North Central Area Committee Meeting

SHD0019/22

**North West Corner of Omni Park Shopping Centre,
Santry Hall Industrial Estate, Swords Road, Santry,
Dublin 9.**

Presentation conducted by Rebecca Greene, Executive Planner, on planning application SHD0019/22 (ABP-314458-22) for the construction of 457 Apartments, Crèche and associated works.

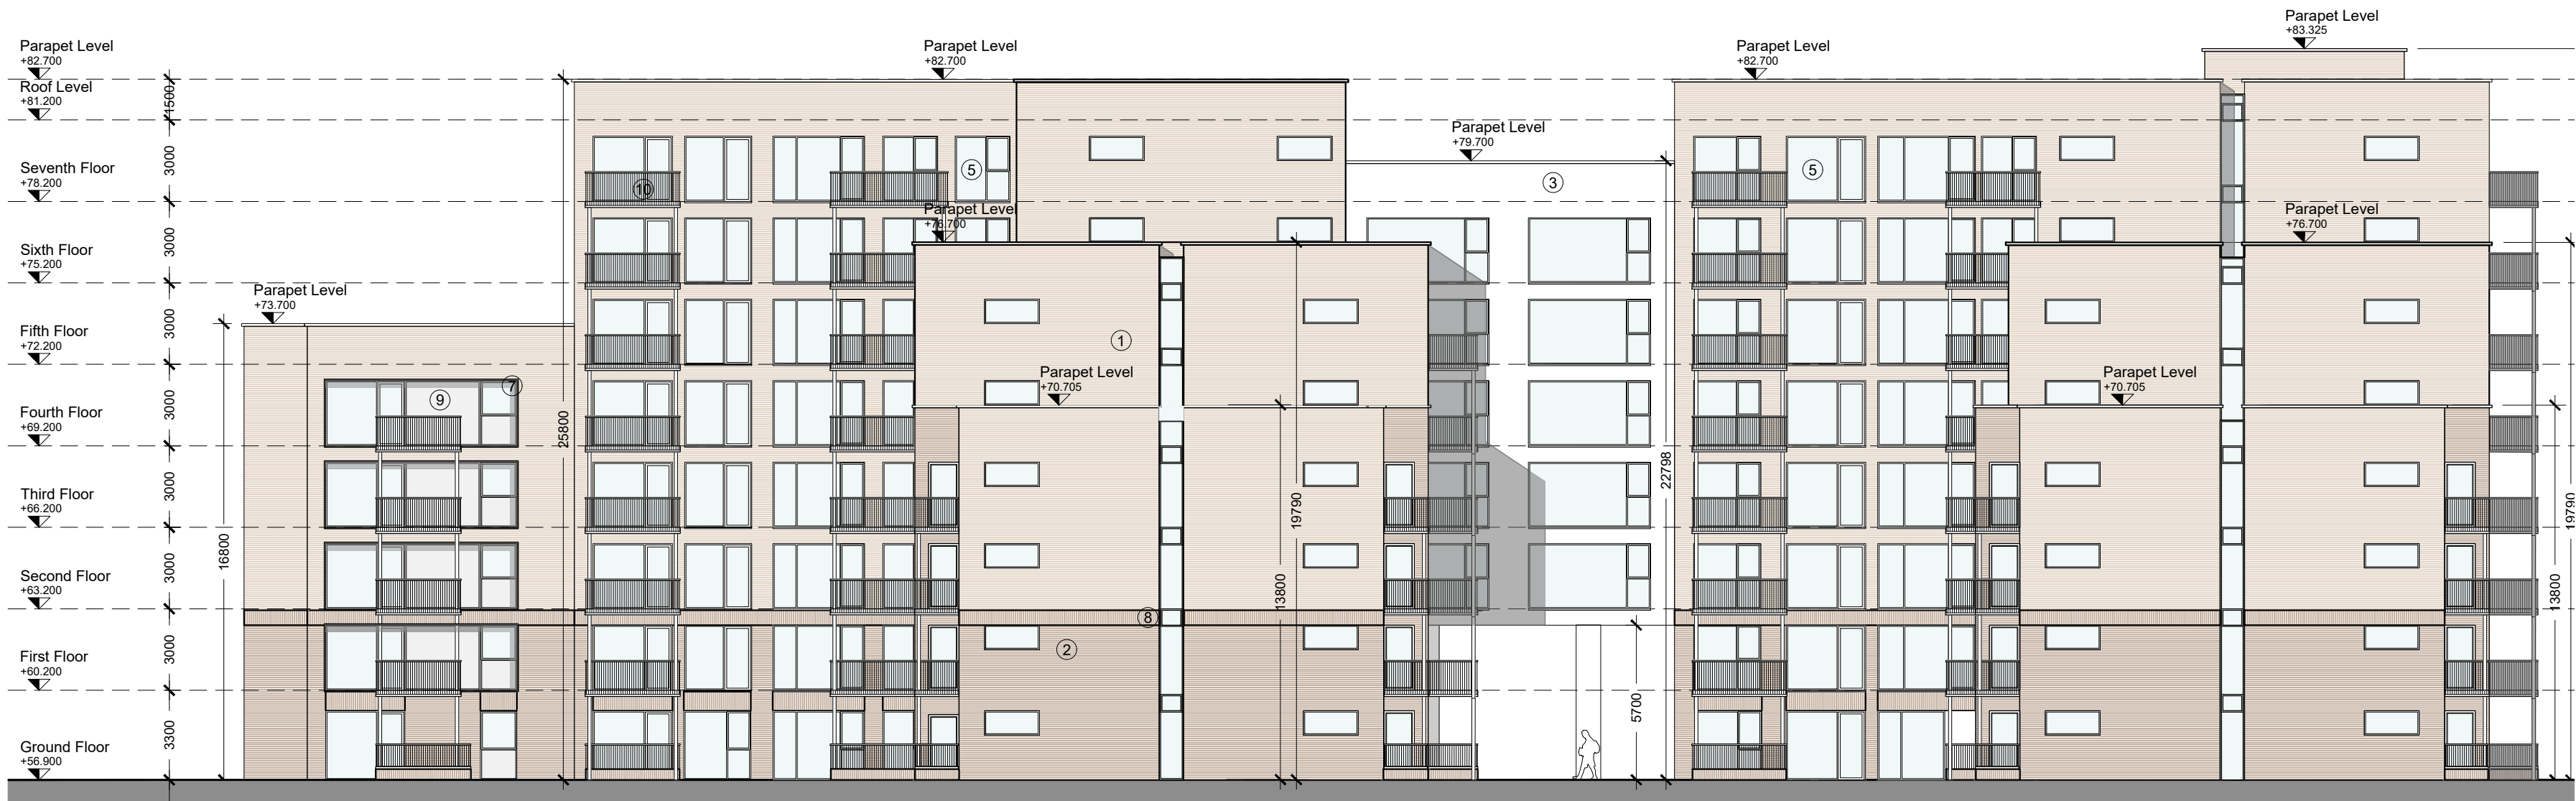
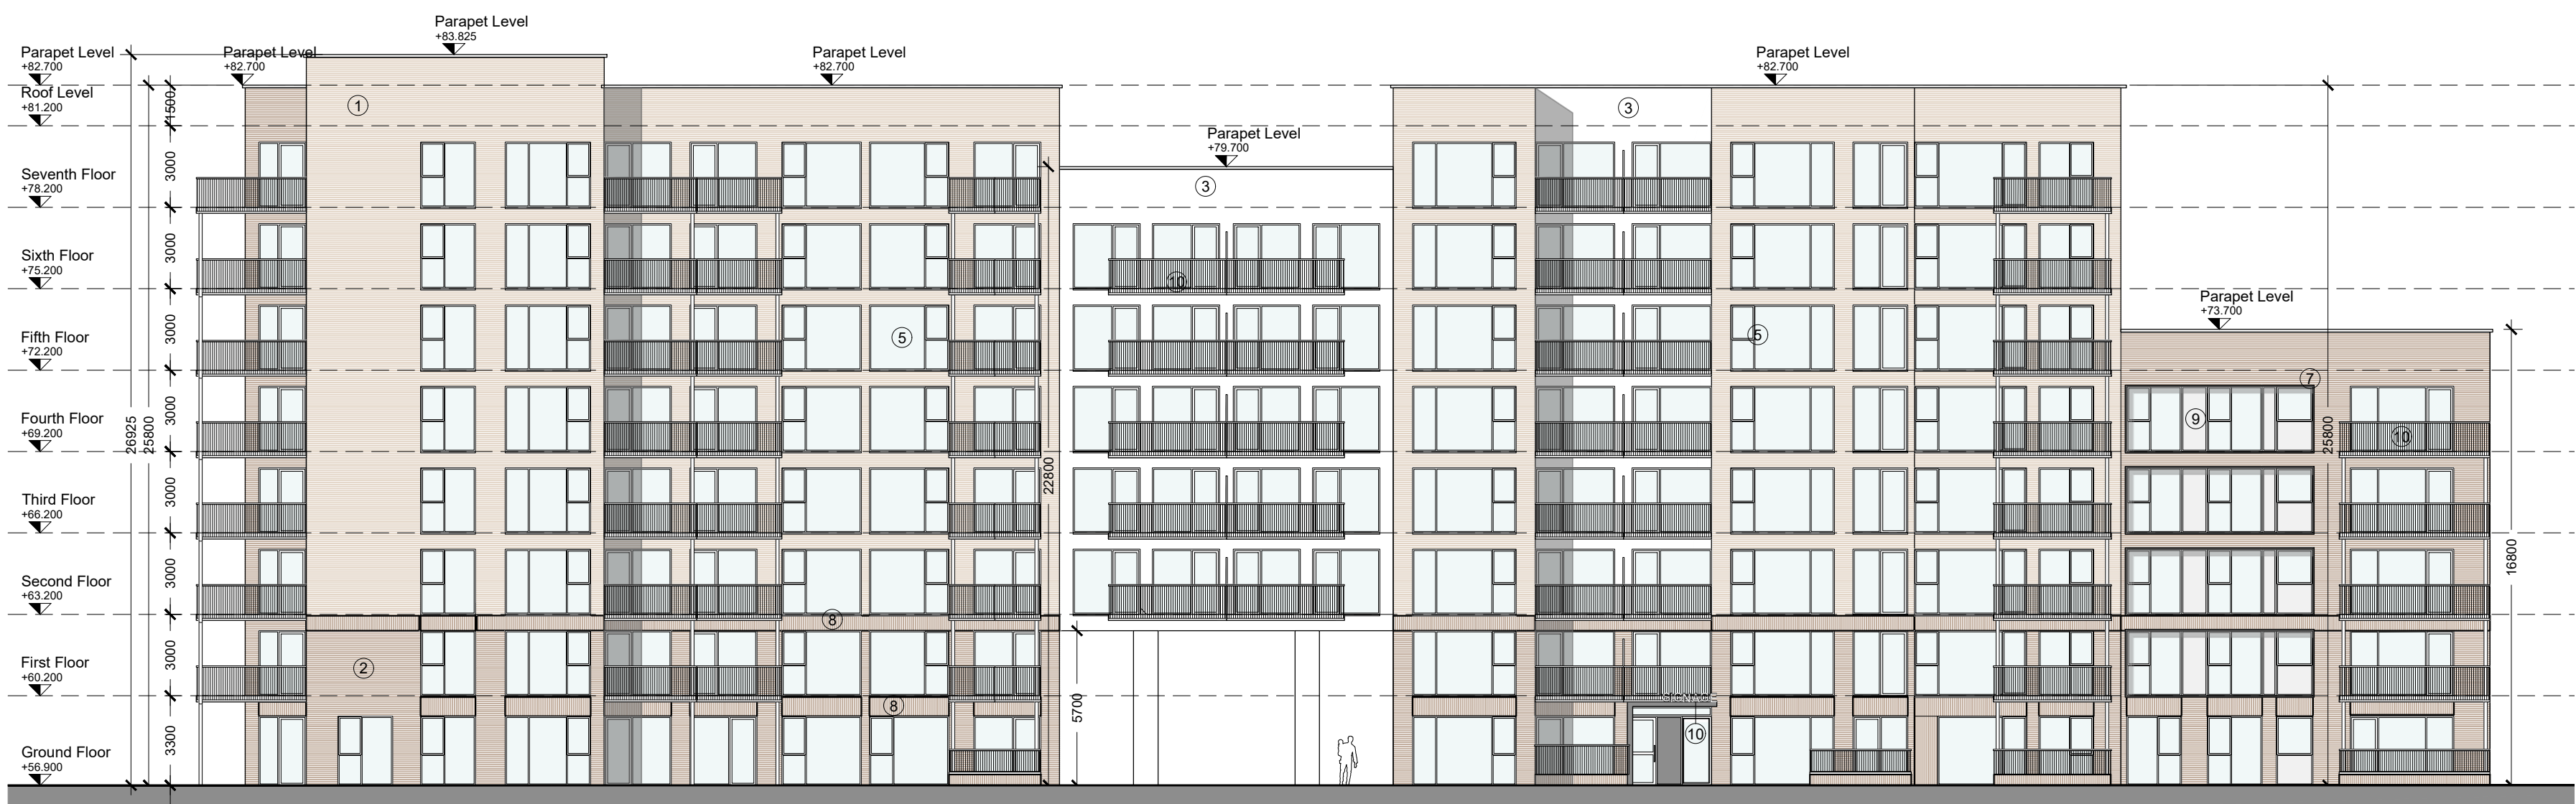
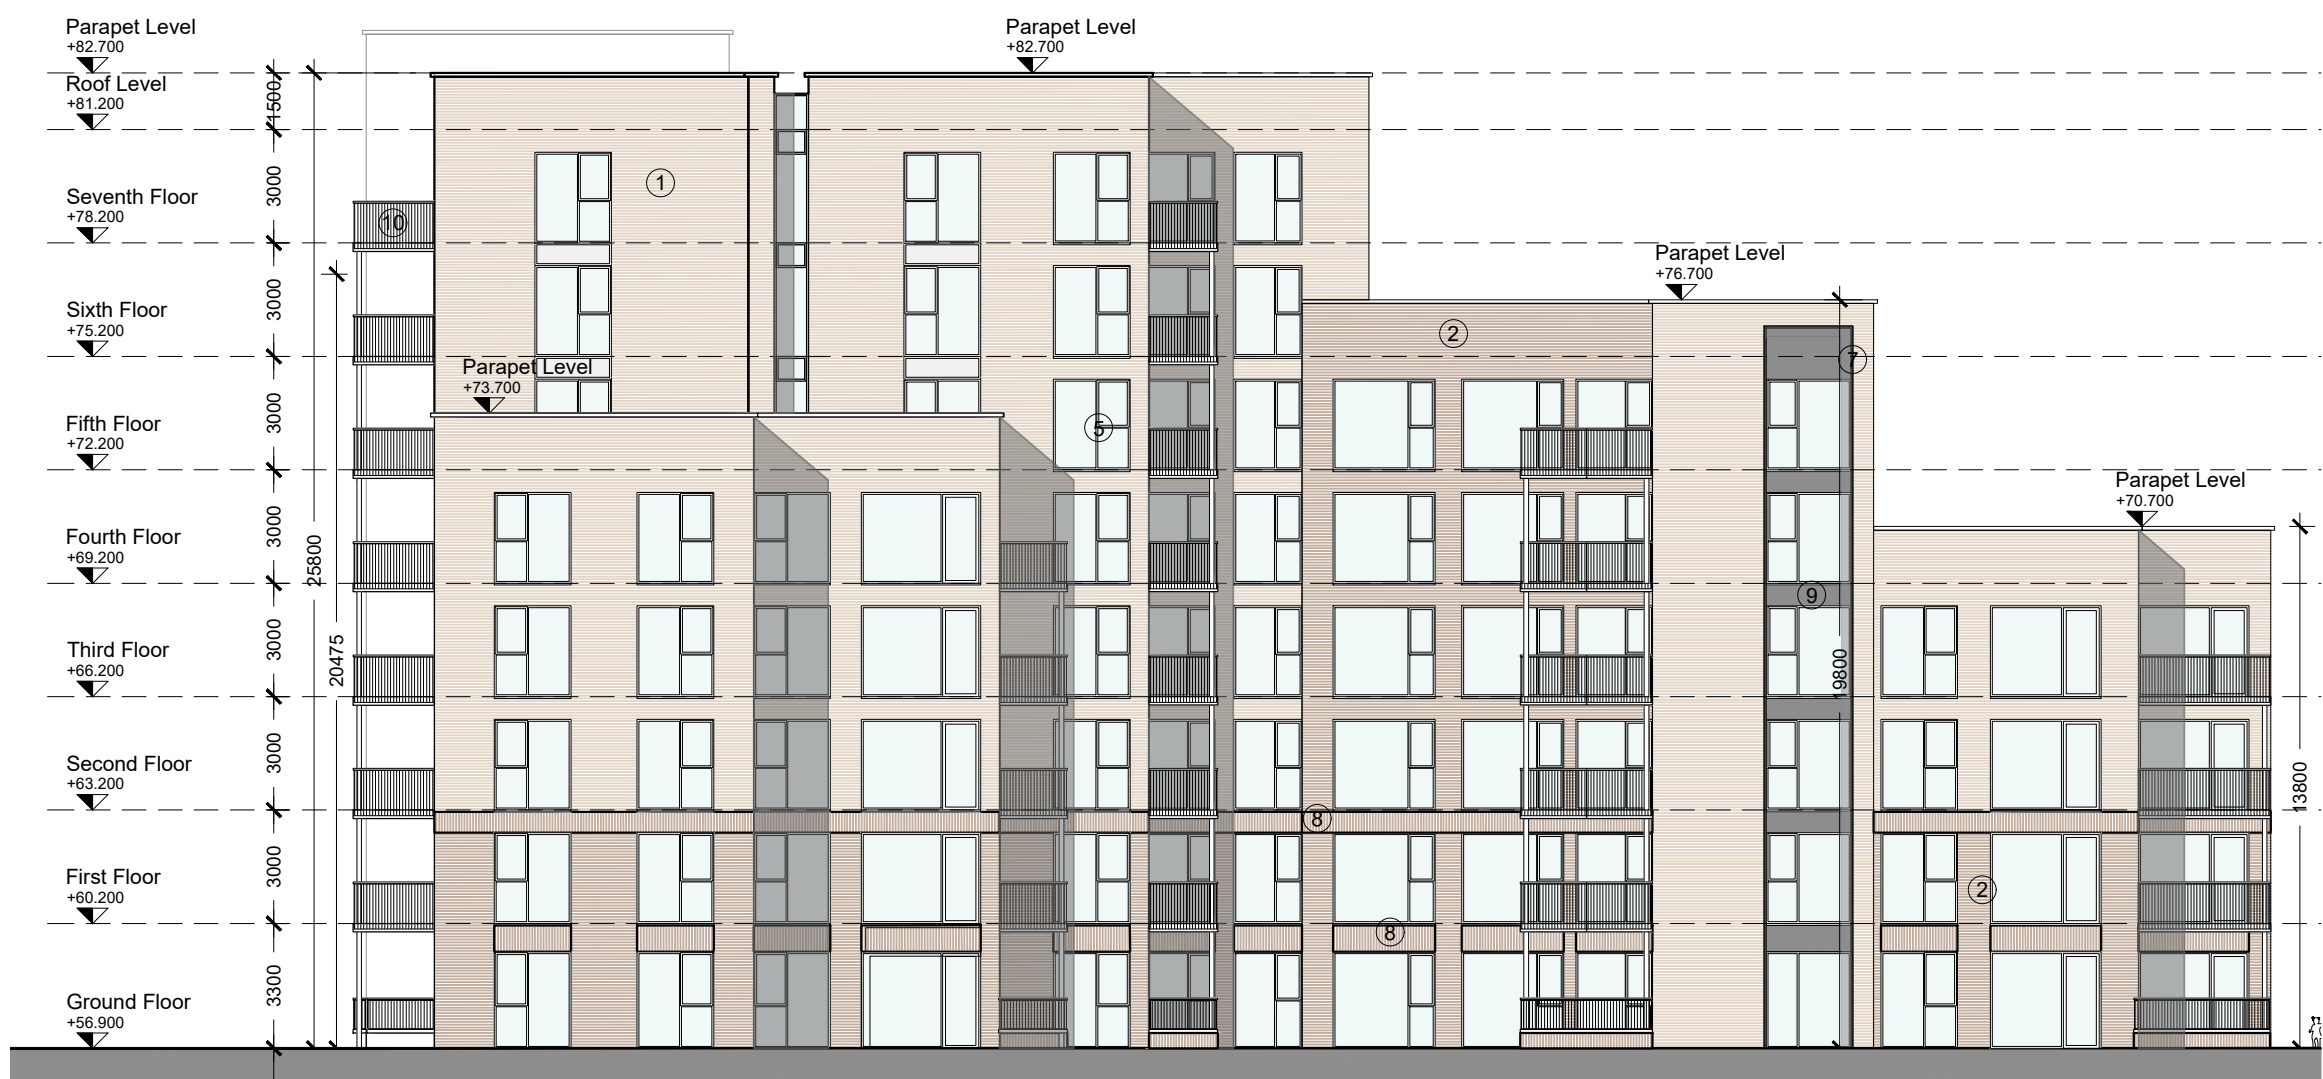
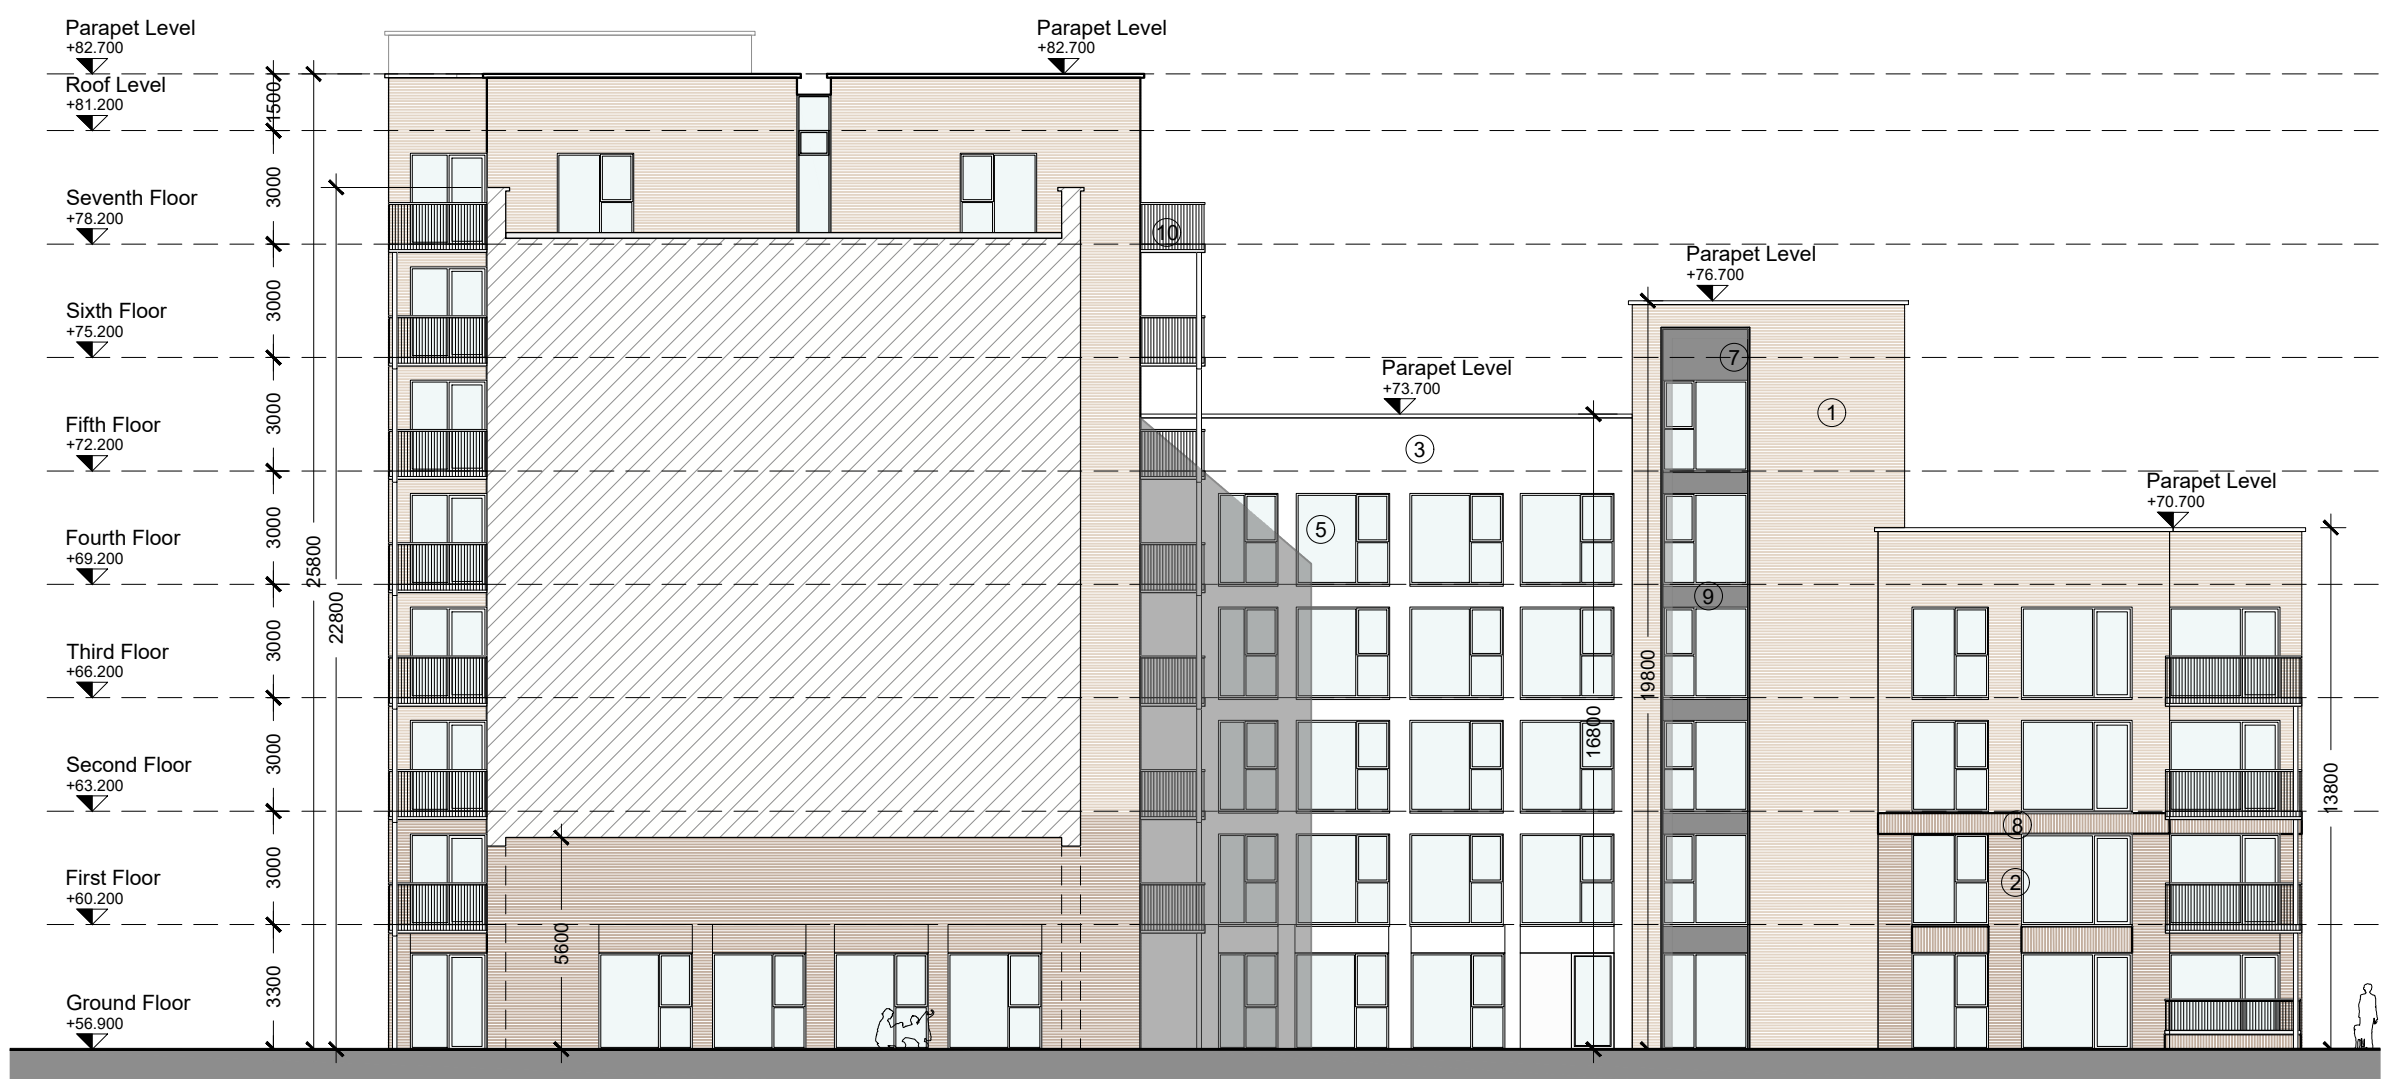
Clarity was also sought in relation to the actual heights in metres of the various blocks in the development and the distances in metres from the prospective development site to Shanliss Ave and concern was expressed of the visual impact on the skyline in a settled two storey residential area and reference made that this application should be declined on the basis of a material contravention
